## Application for a non-material amendment following a grant of planning permission. Town and Country Planning Act 1990

ERECTION OF A TWO STOREY SIDE EXTENSION AND SINGLE STOREY REAR EXTENSION (RE-SUBMISSION 23/0037)

Reference number: 23/0868

DRAWING NUMBER
729-02

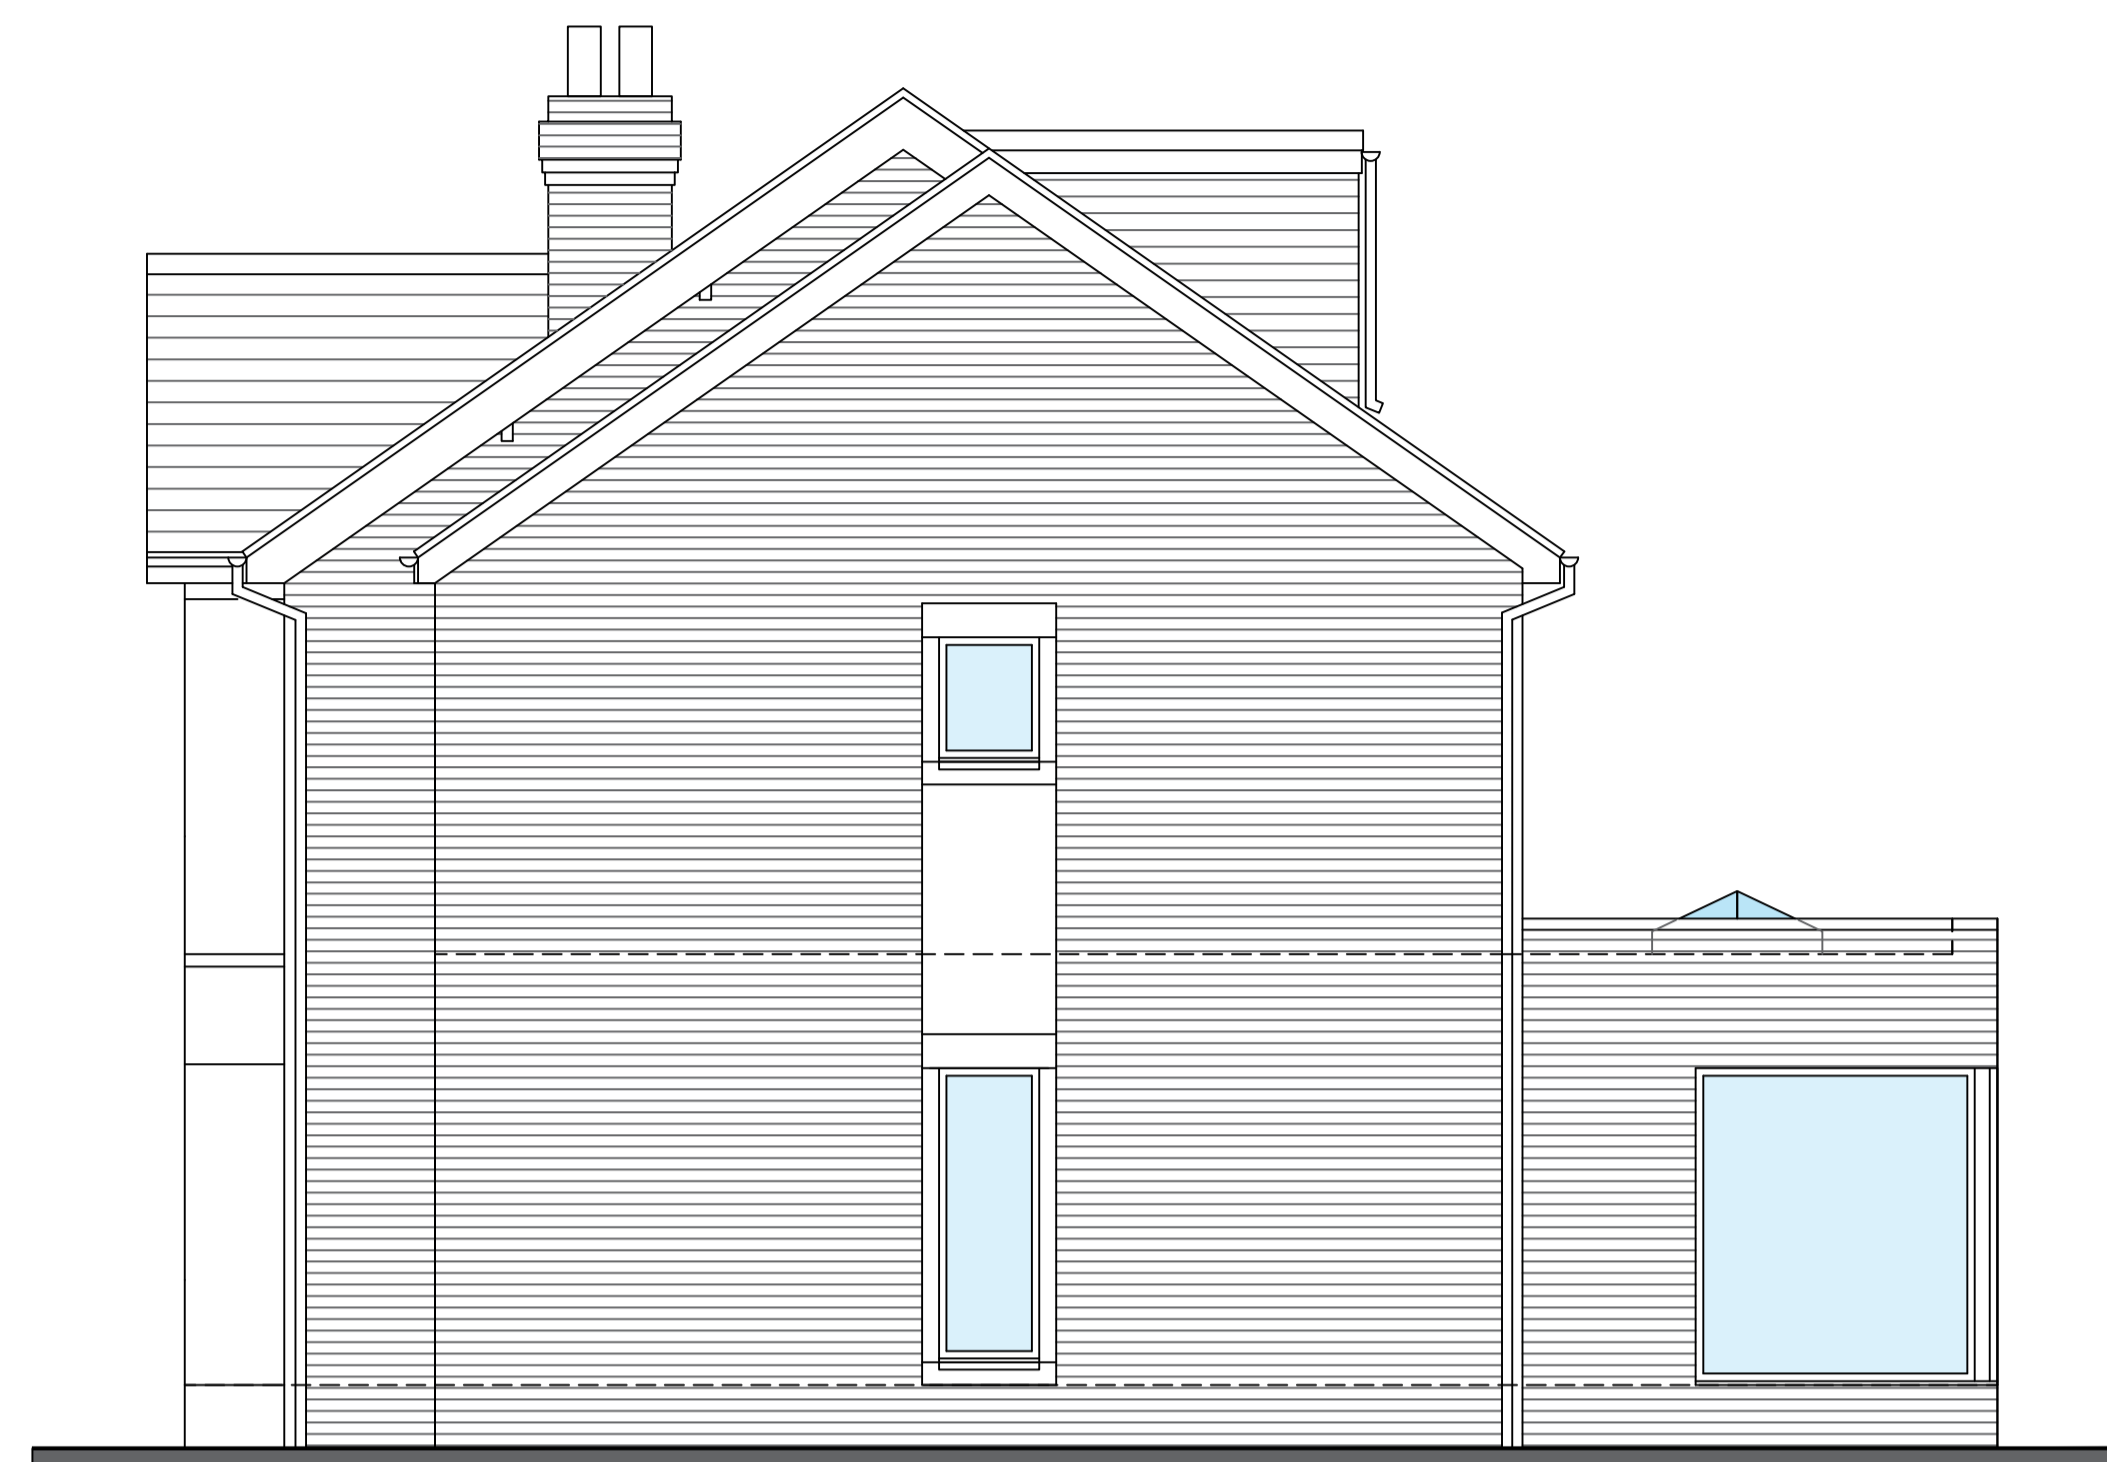
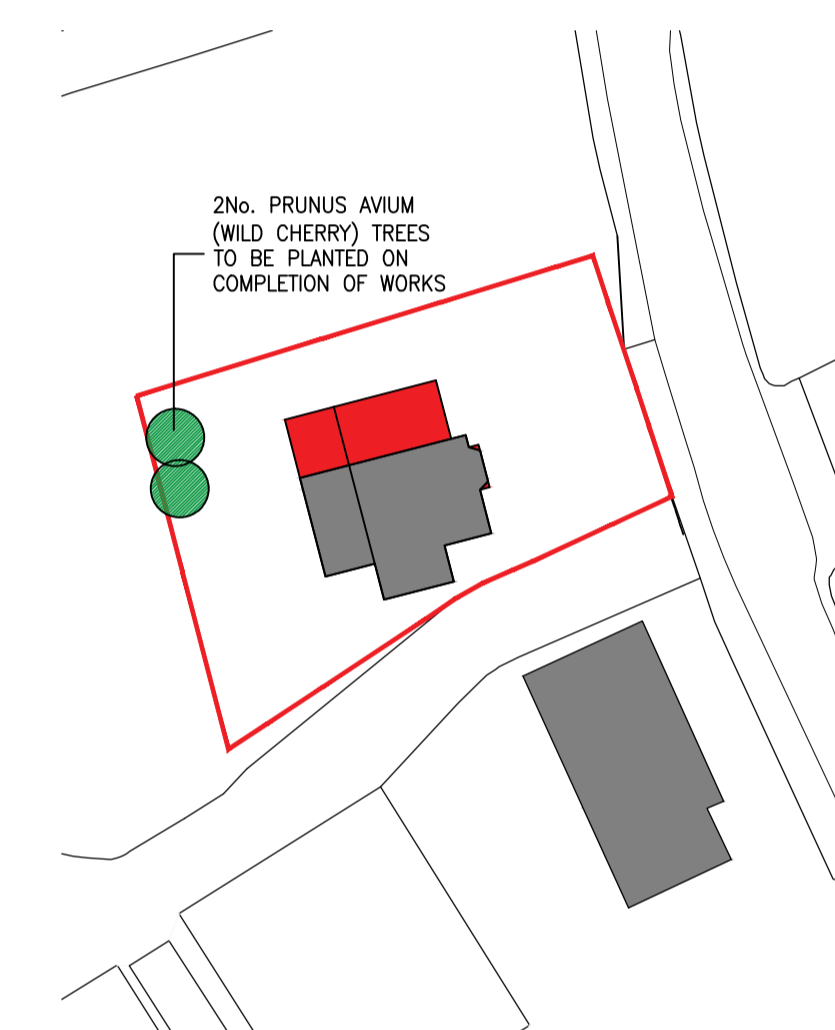
RE DESIGN OF FRONT BAY TO INCLUDE ENTRANCE DOORS AND REPLACING FORMER ENTRANCE DOOR WITH WINDOW. SUBSTITUTION OF TWO STOREY BAY TO SIDE EXTENSION TO 2 NO. WINDOWS.

THE APPLICANT WANTS TO RELOCATE MAIN ENTRANCE AND WISHES A MORE MODERN BAY. ENTRANCE CENTRED PROVIDES BETTER BALANCE VISUALLY.

New plan/drawing number(s): PROPOSED ELEVATIONS, SITE + SITE LOCATION PLANS 729-02 REV D PROPOSED PLANS 729-01 REV B.
